Our ref: DOC20/958285

**Additional Information following Response to Submission comments for Parramatta Powerhouse (SSD-10416)**

TITLE
ST GEORGES TERRACE - PROPOSED PLANS

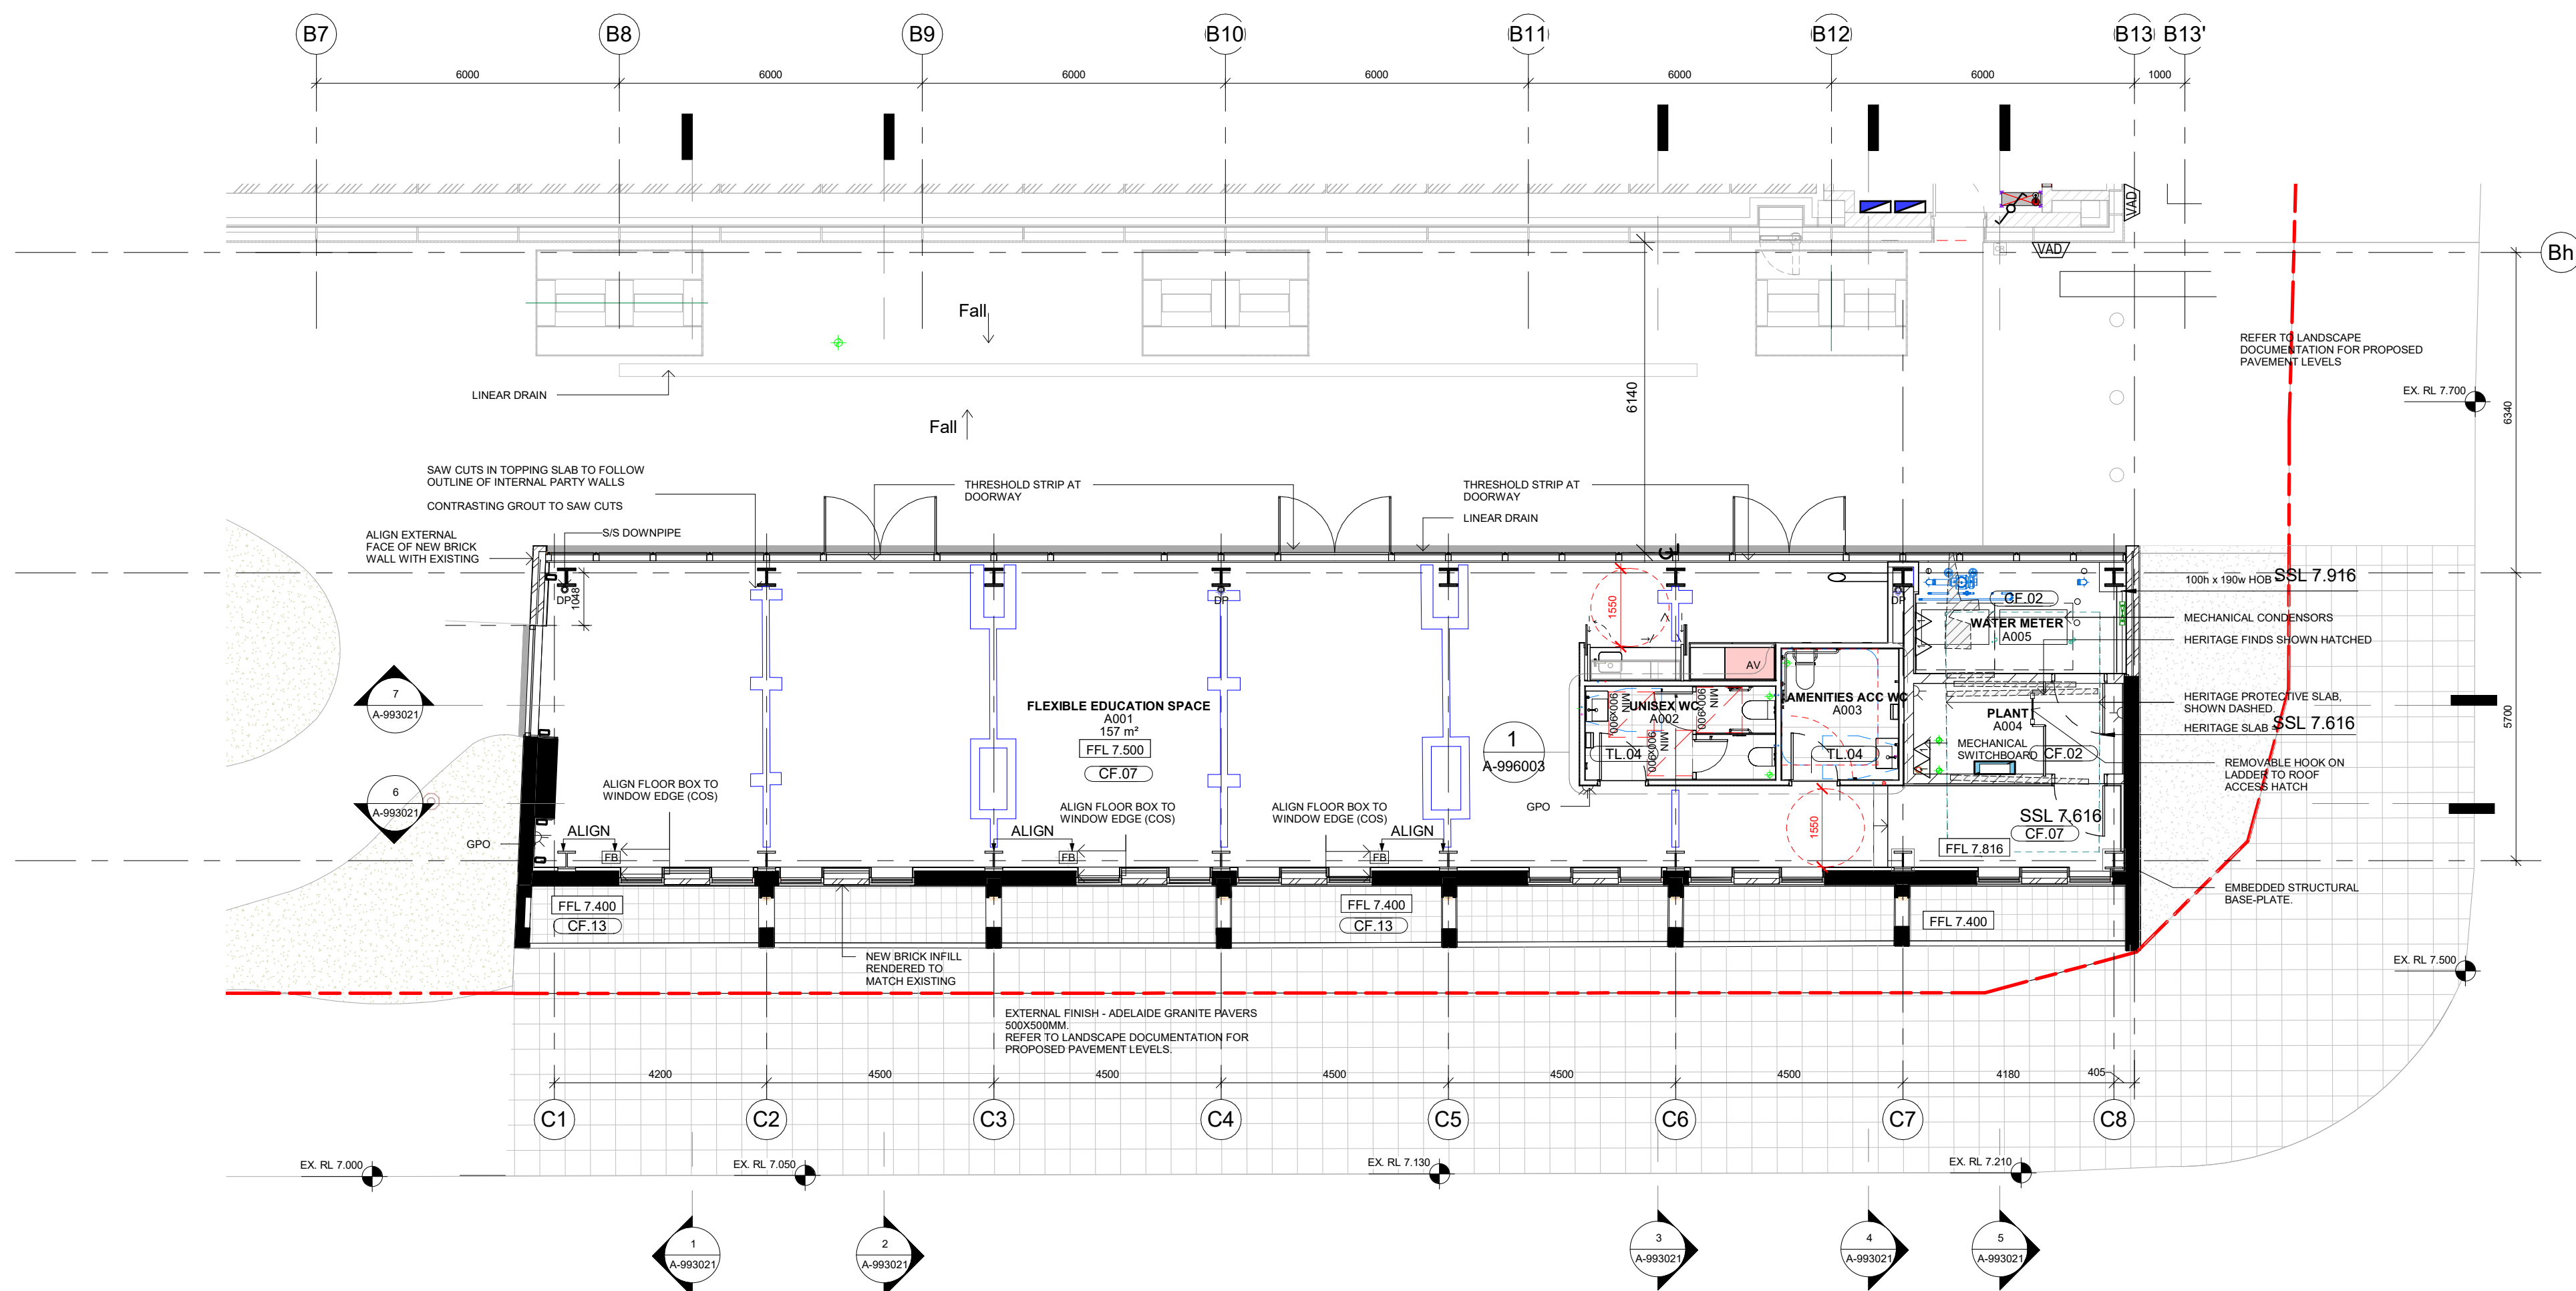
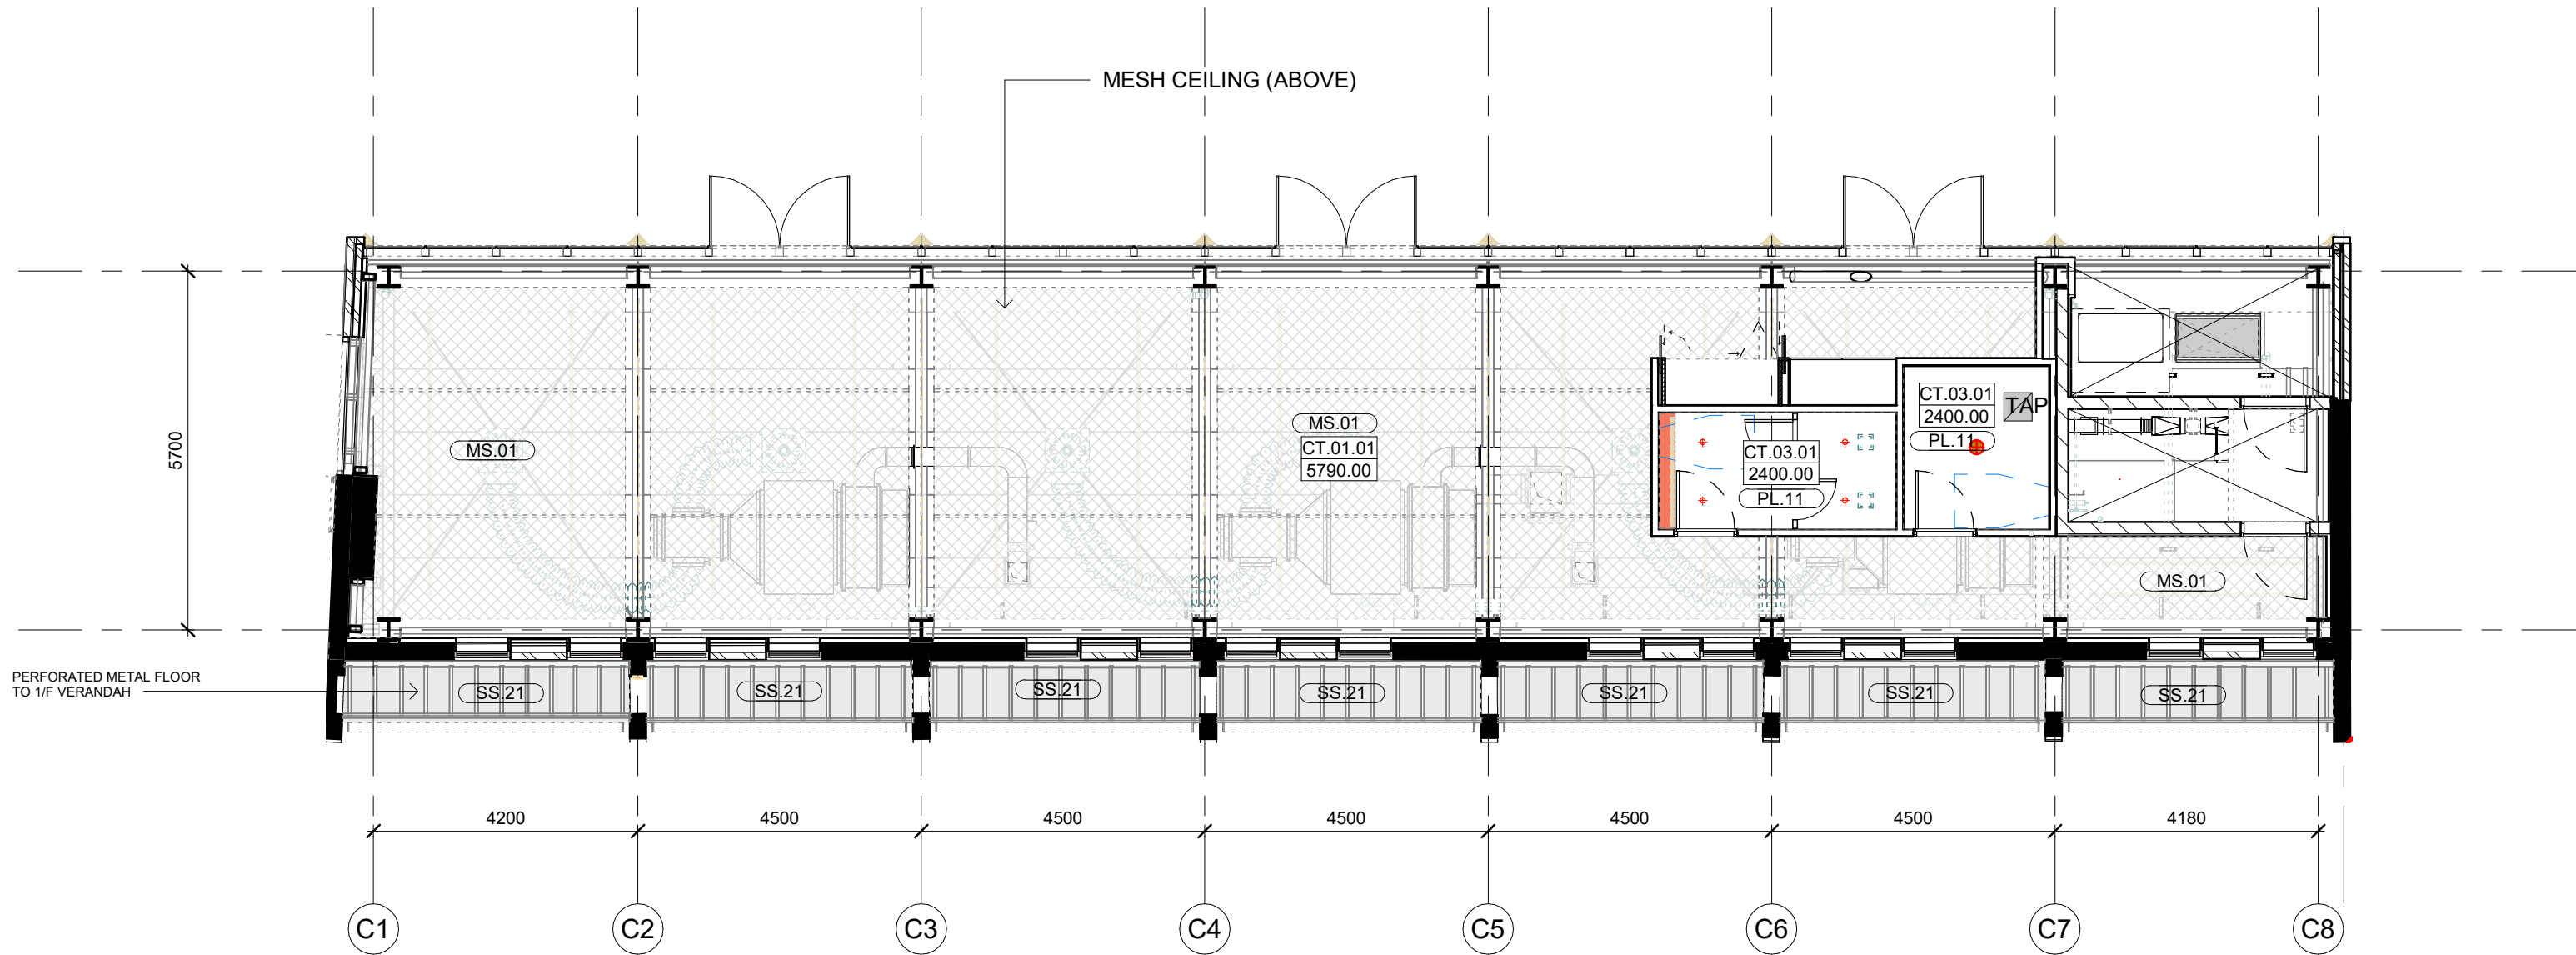
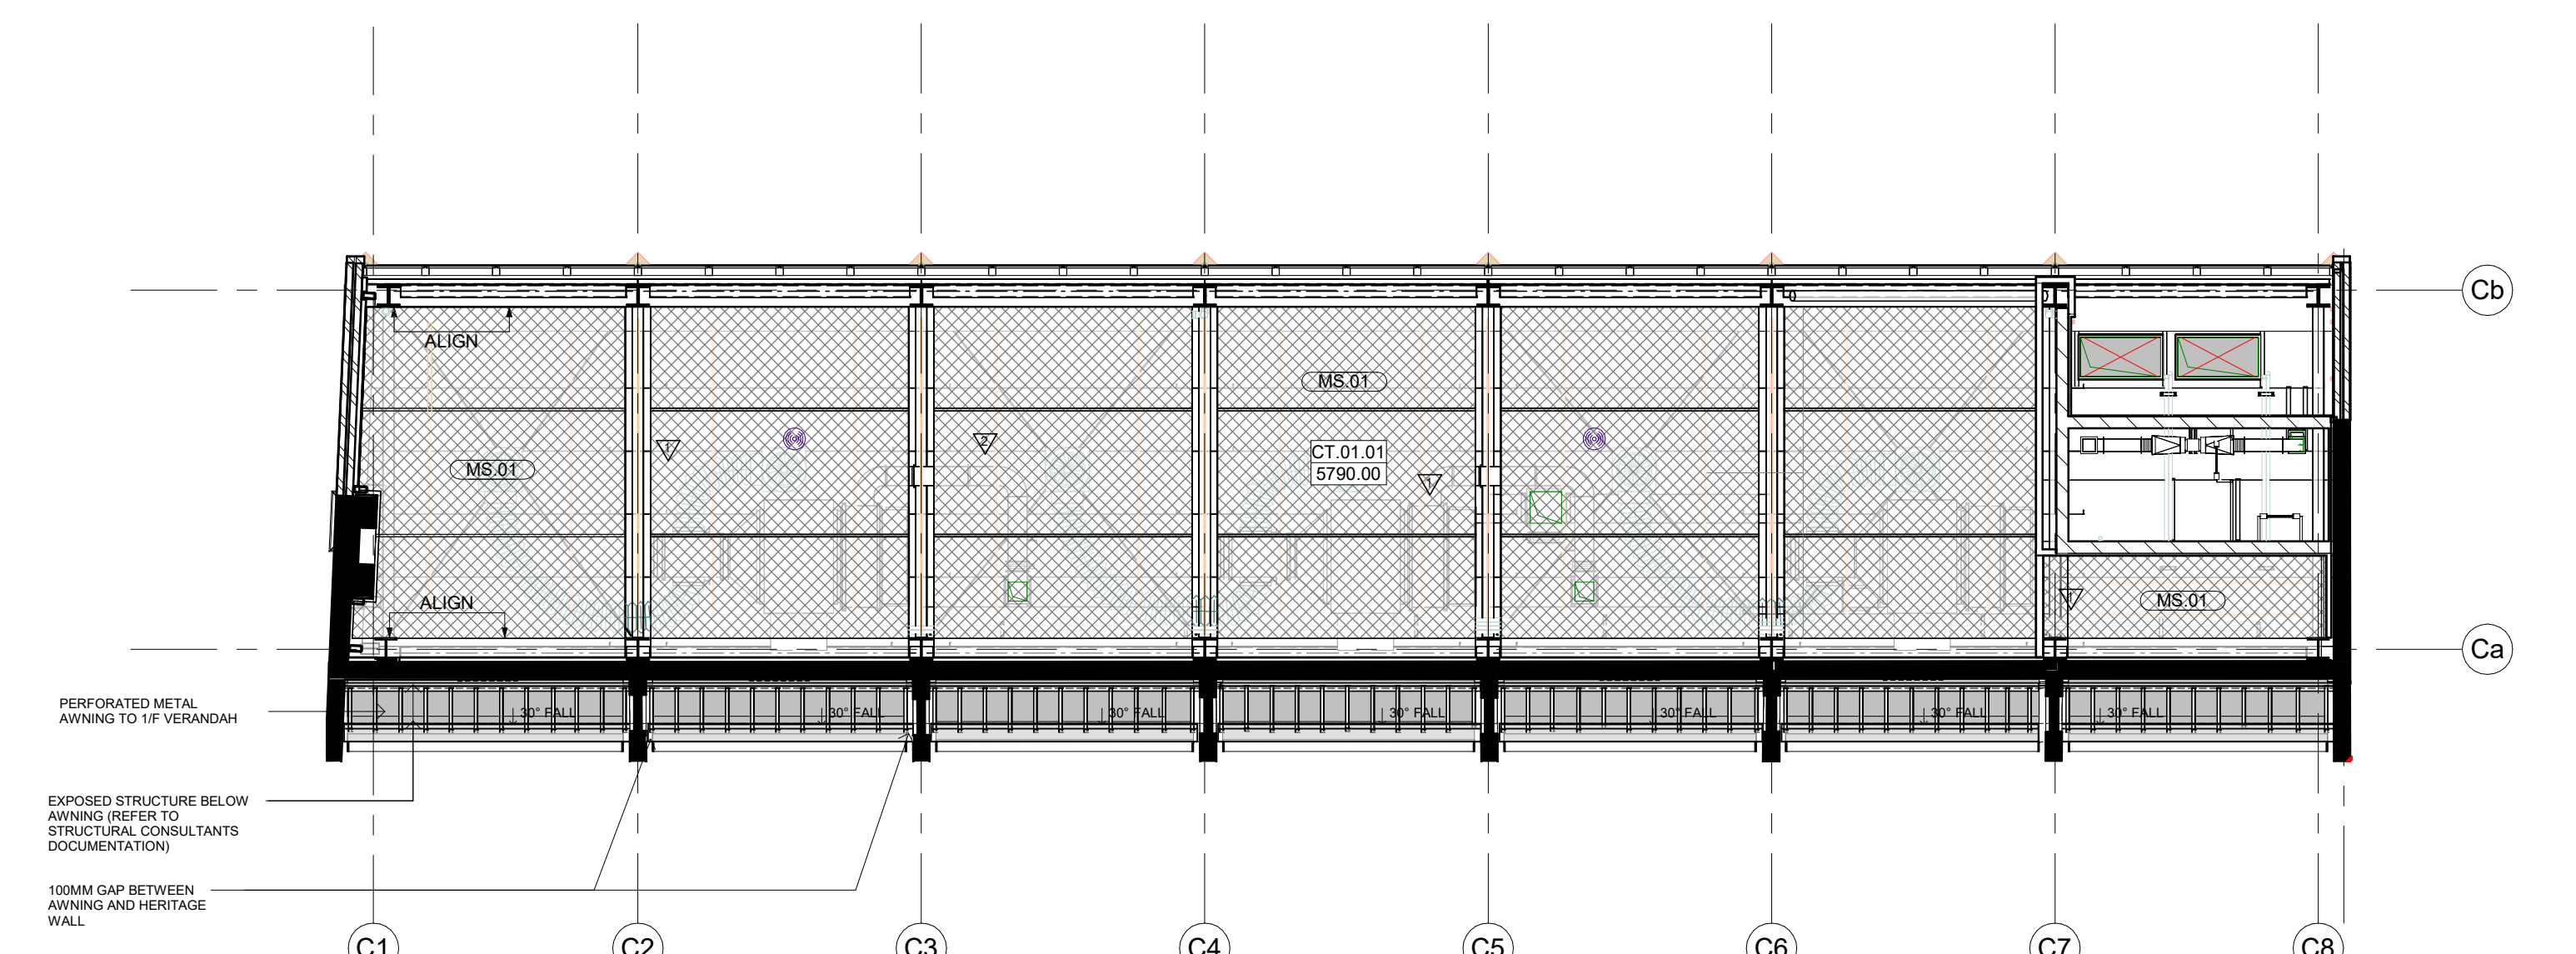
1. The addendum SOHI advises an Option 2 as the preferred option for managing the St Georges Terrace built heritage element. This would involve a c.5.065m set back, demolition of the brick rear addition and demolition of c.1.688 metres of St Georges Terrace. As previously advised for local heritage items within the project area, Heritage NSW's recommends that the Project responds to advice of the City of Parramatta Council. We will not make a comment on the proposed impact to this locally significant heritage item.
